# H2Teesside Project

Planning Inspectorate Reference: EN070009

Document Reference: 8.11.8 Response to ExQ1 Cumulative and Combined Effects

**Applicant: H2 Teesside Ltd**

FIGURE NUMBER
Figure 23-2 (Sheet 1 of 2)

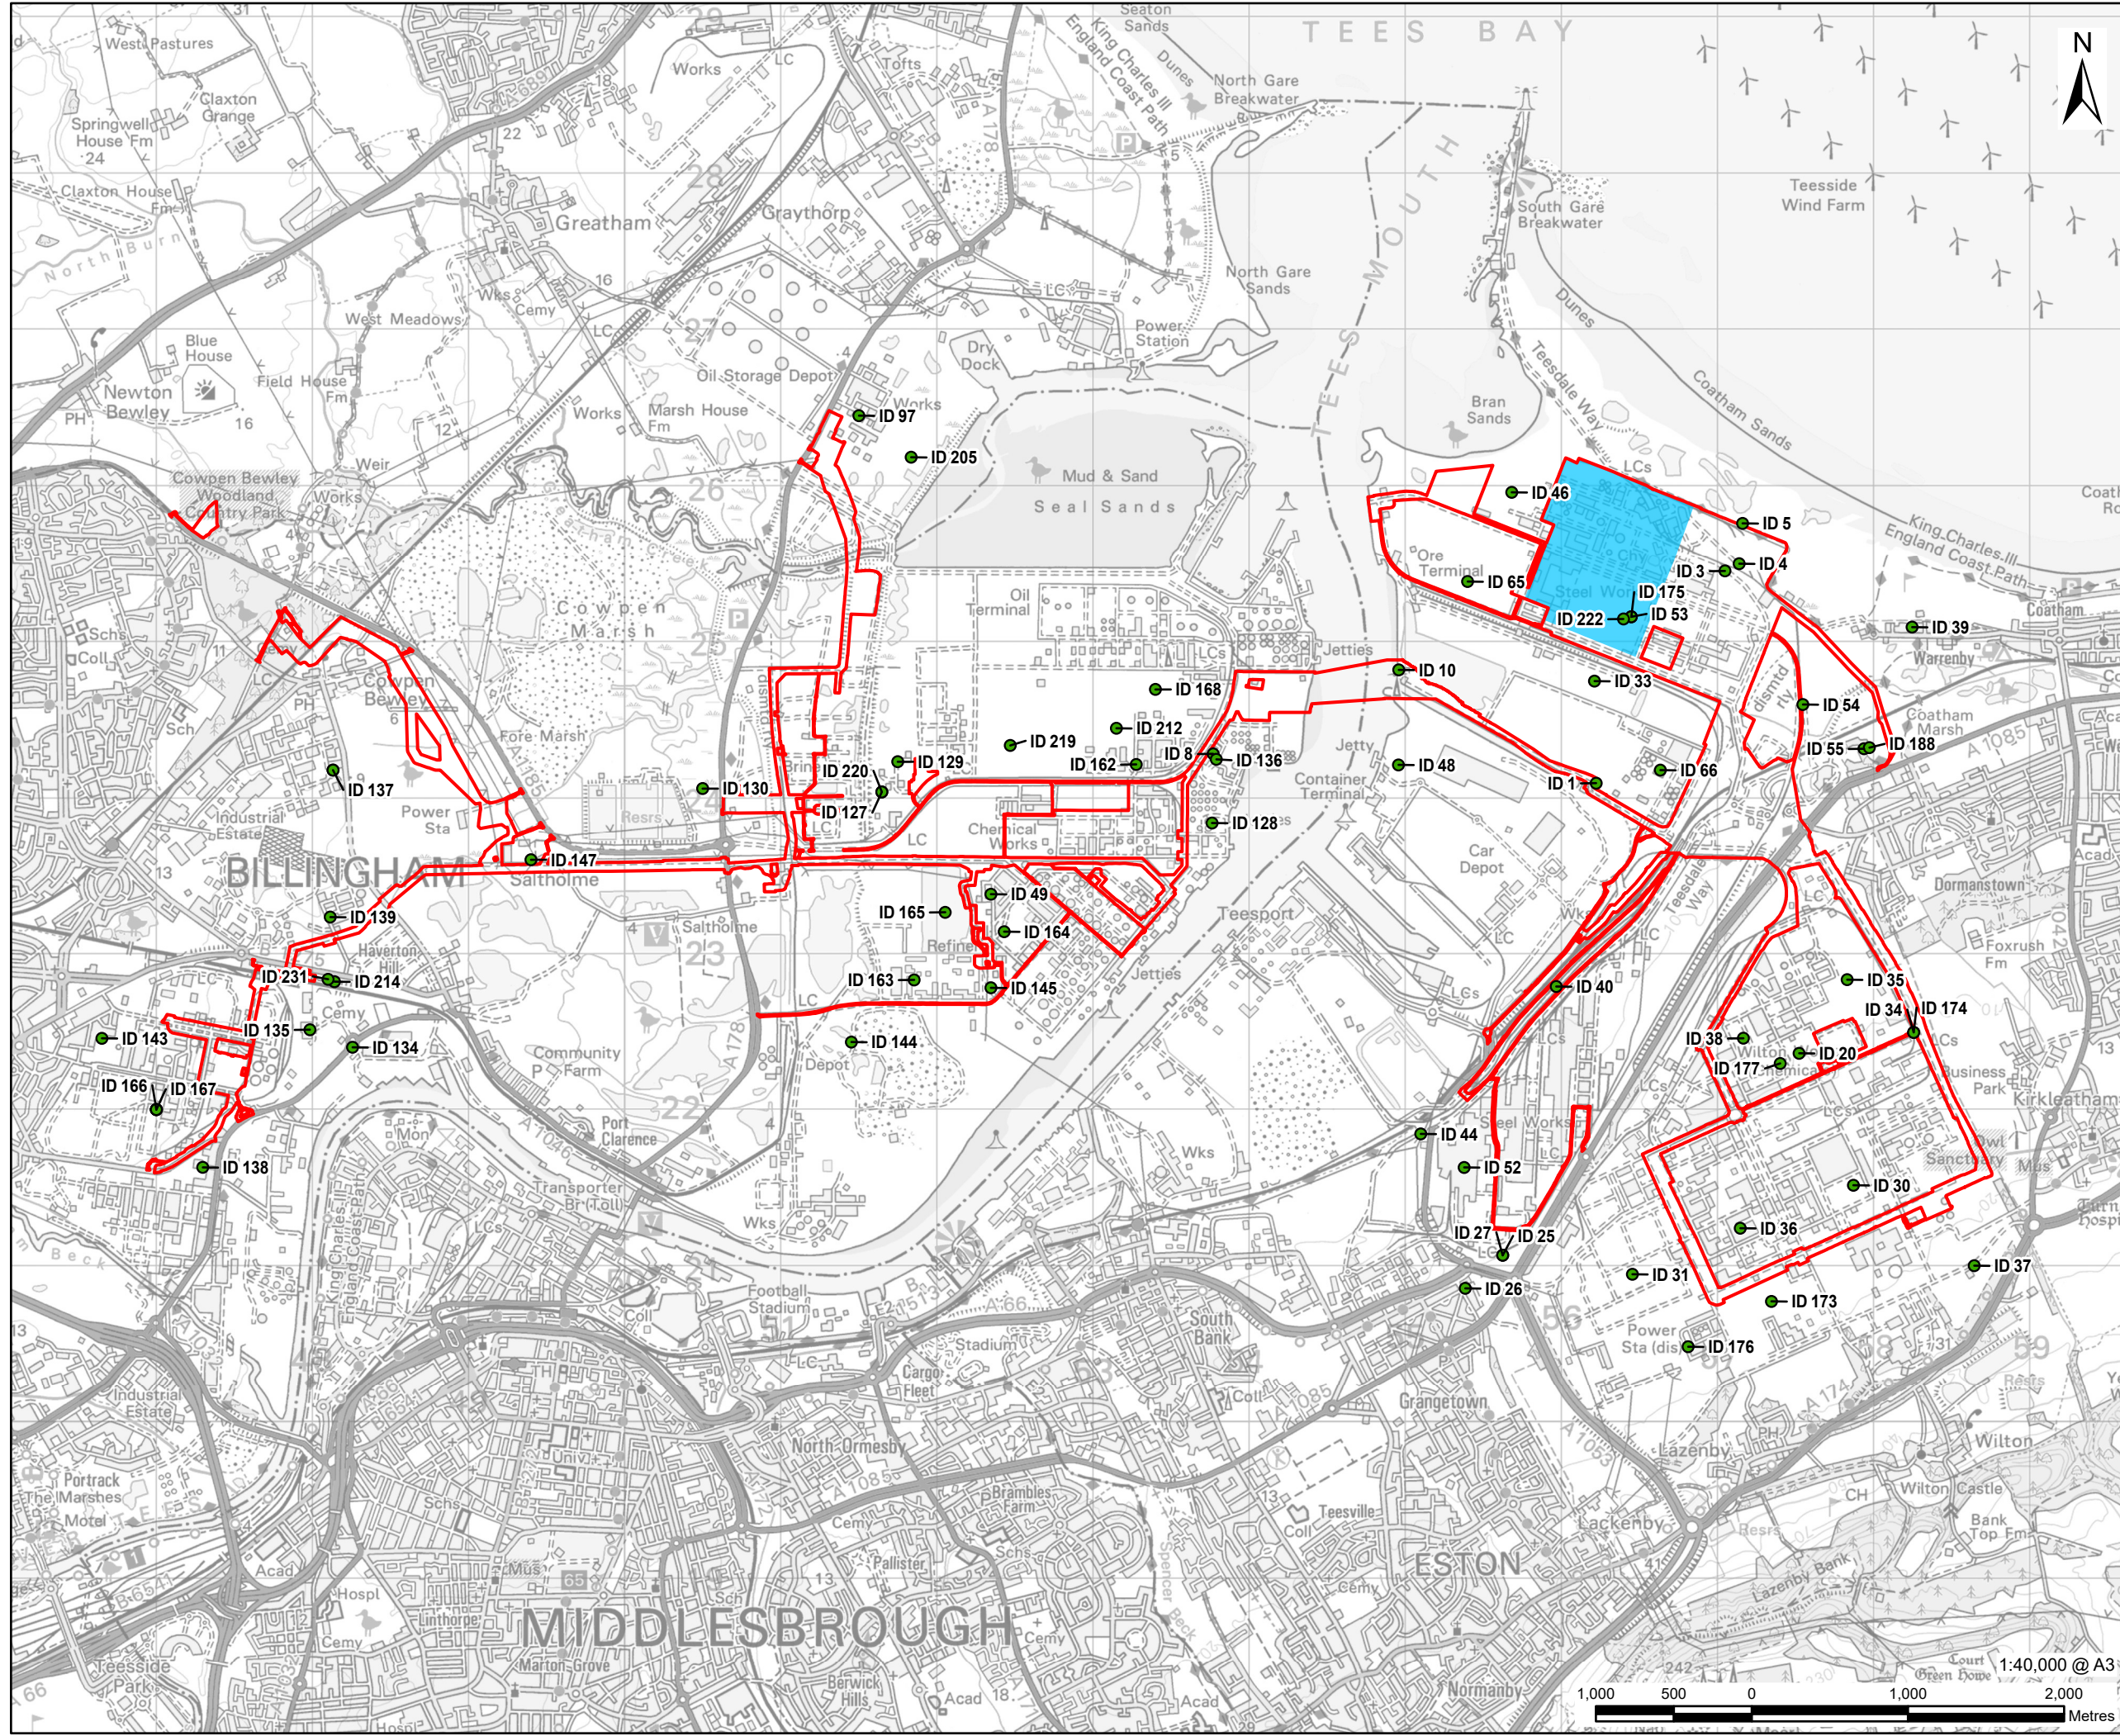
Q1.8.2	Applicant	<p>Other Developments.</p> <p>For ease of reference, please add a table insert to Figure 23-2 which shows information already included in Appendix 23A to detail the other developments highlighted on that plan. The table column headings requested are ID; Planning Authority; Applicant and Scheme Title; Timescale Summary; and Status.</p>	<p>The Applicant is currently preparing an updated Cumulative and Combined Effects Assessment. The Applicant has not been able to update Figure 23-2 [APP-181] in the timeframe as requested. The update would require a table showing information for the 235 sites listed in Appendix 23A, which will not be able to be shown on one figure. Furthermore, the updates to the Cumulative and Combined Effects Assessment (which are explained in the response to FWQ 1.8.3 below), will result in additional sites to be shown on an amended Figure 23-2 [APP-181]. The Applicant proposes to submit all updates to Figure 23-2 [APP-181] at Deadline 5.</p> <p>The Applicant notes that to meet this request it would be necessary to split Figure 23-2 into approximately 24 sheets to allow an insert table on each with the requested information. The Applicant can do this for Deadline 5 if this is considered agreeable by the ExA, but would be grateful for confirmation that this approach is still wanted, in light of that context as it will take some preparation to complete.</p>
